# **CHATBURN PARISH COUNCIL**

## **Planning Application No. 3/2014/1089 – land off Clough Bank Lane**

Project Proposed Dwelling to land behind The Manor House, Clough Bank Lane, Chatburn, For Mr and Mrs Harrison.		File Name 114-5	
Title PROPOSED SITE PLAN		Date 14/11/11	Drawn 247
Scale 1-250

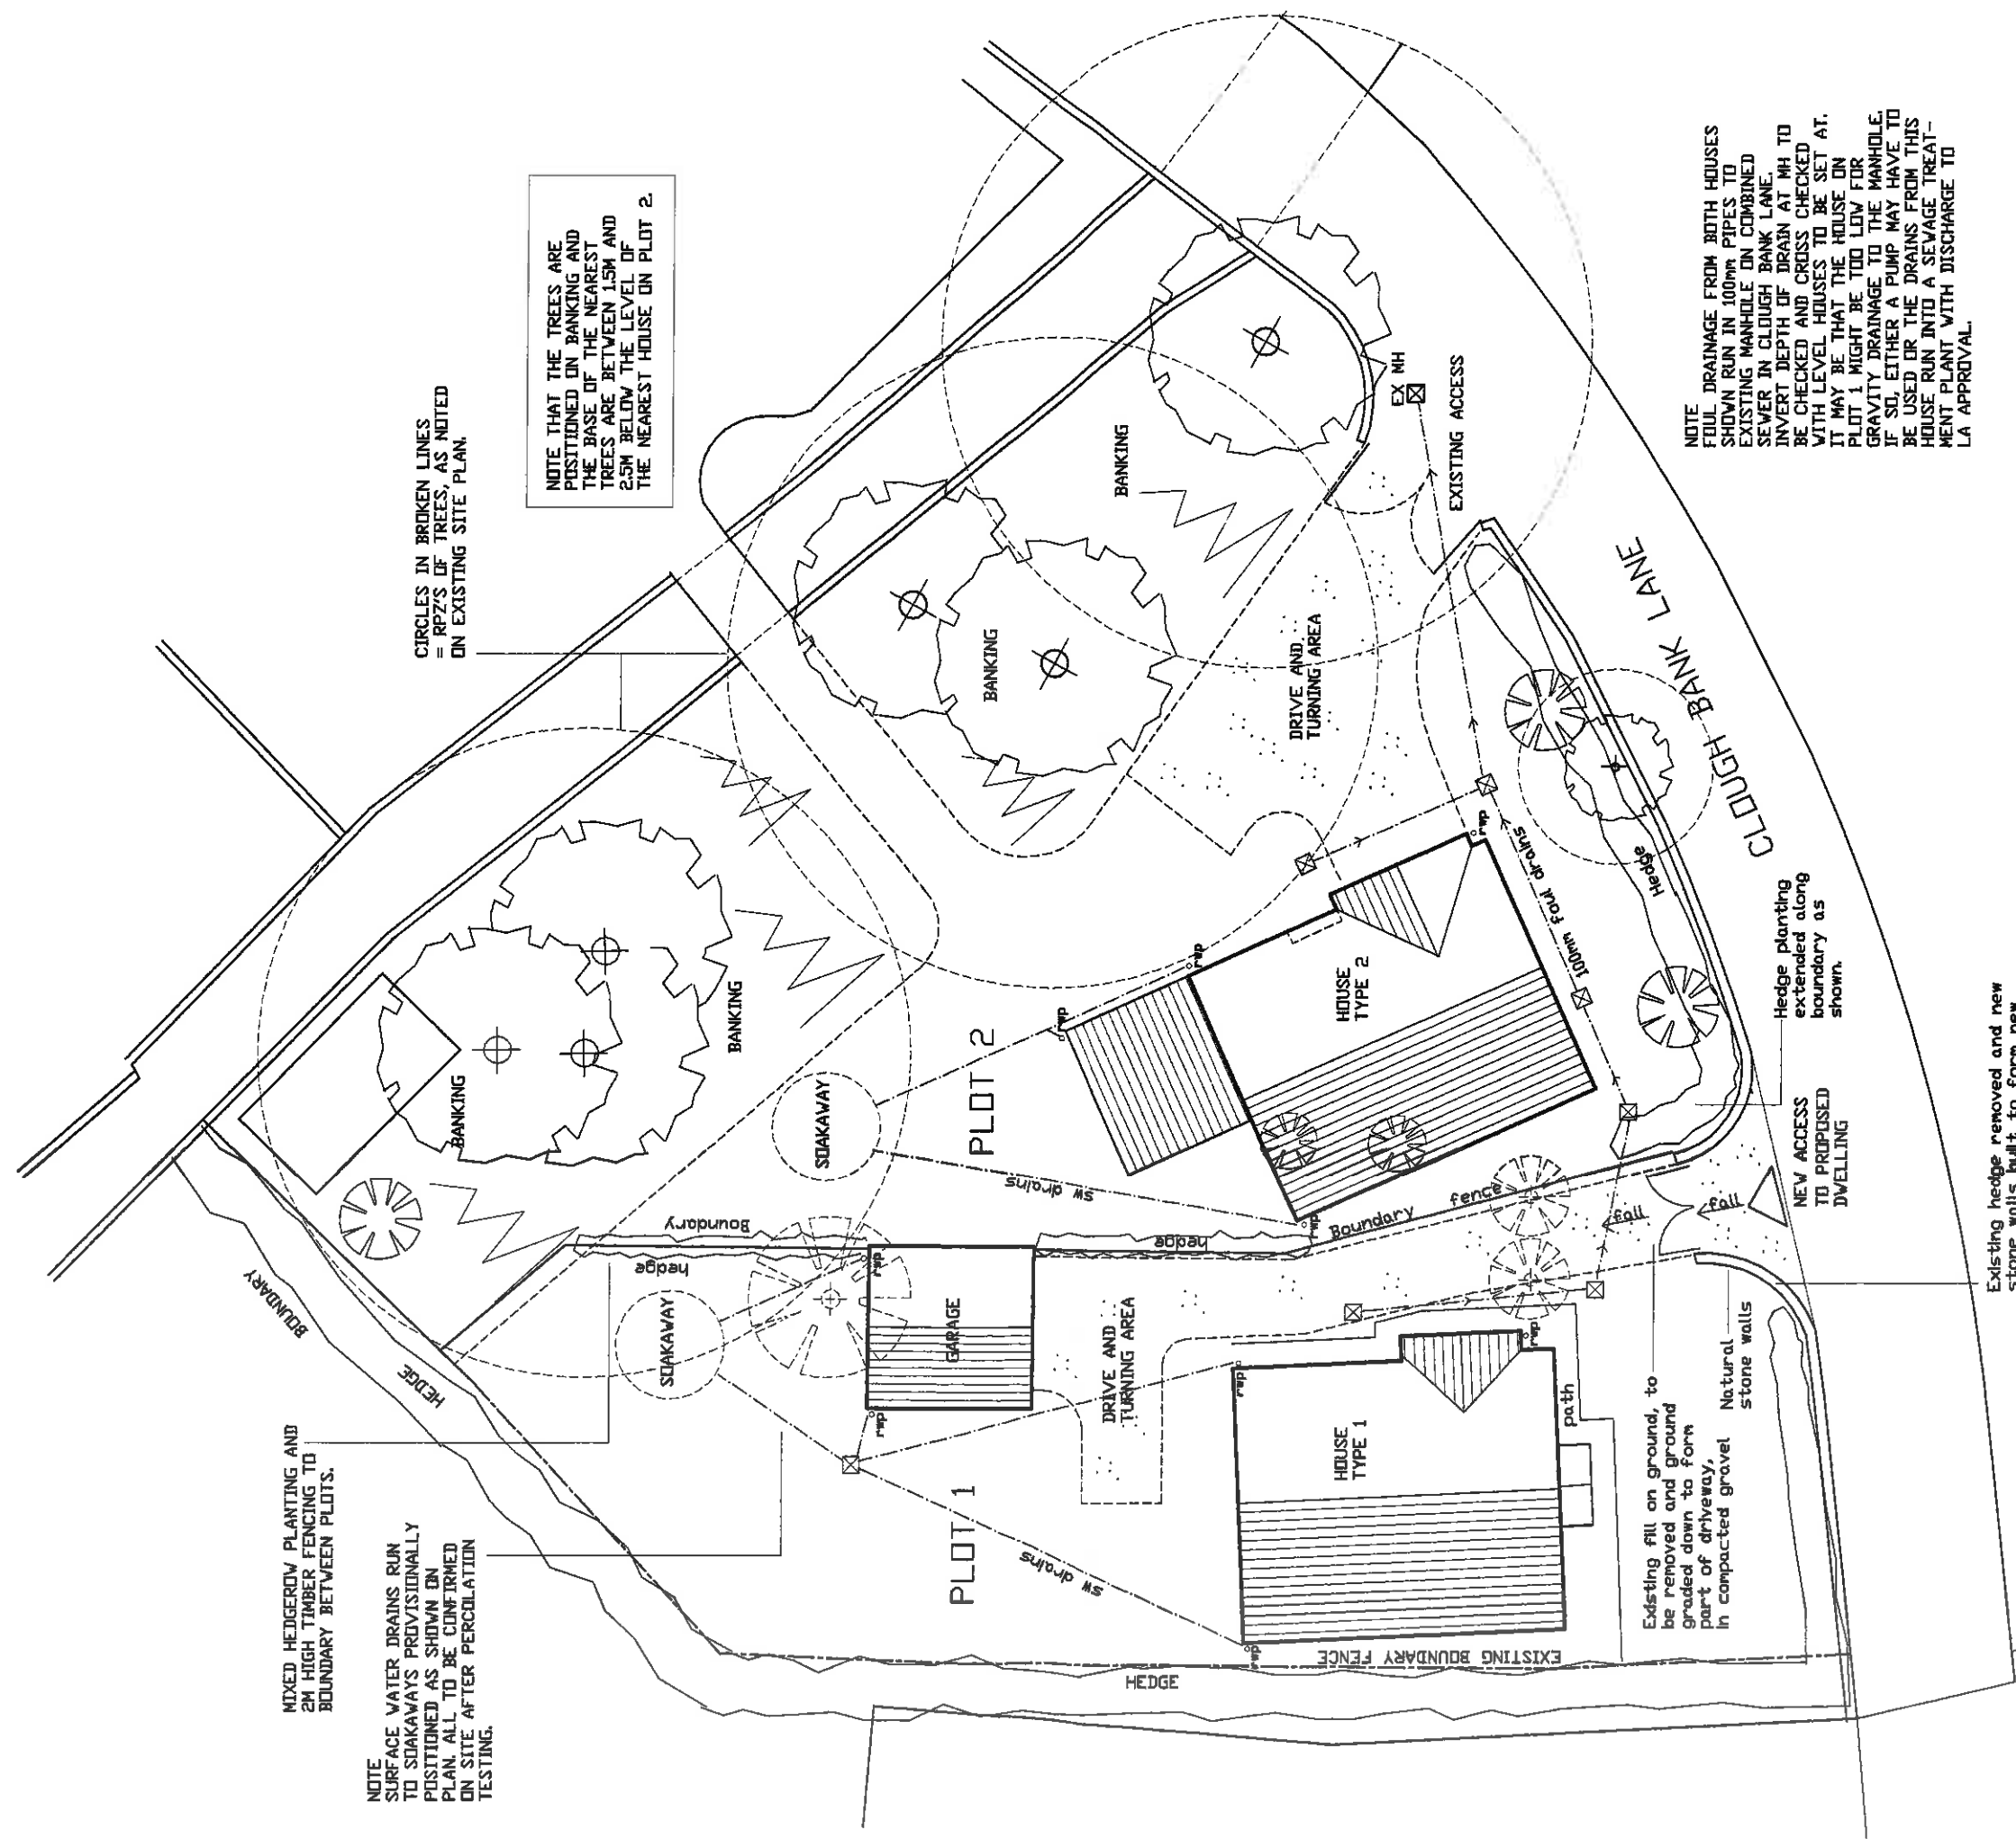
1. Following the approval for an extension to the building in the 2003, the owners agreed to allocate the land adjacent to the single dwelling for use of a car park to alleviate parking problems on Clough Bank, Bridge Road and Downham Road.
2. The new application to build two houses will provide no car parking for staff.
3. There is concern that the Heys Brook bridge on Clough Bank is not sufficiently strong enough to carry service vehicles and construction traffic.
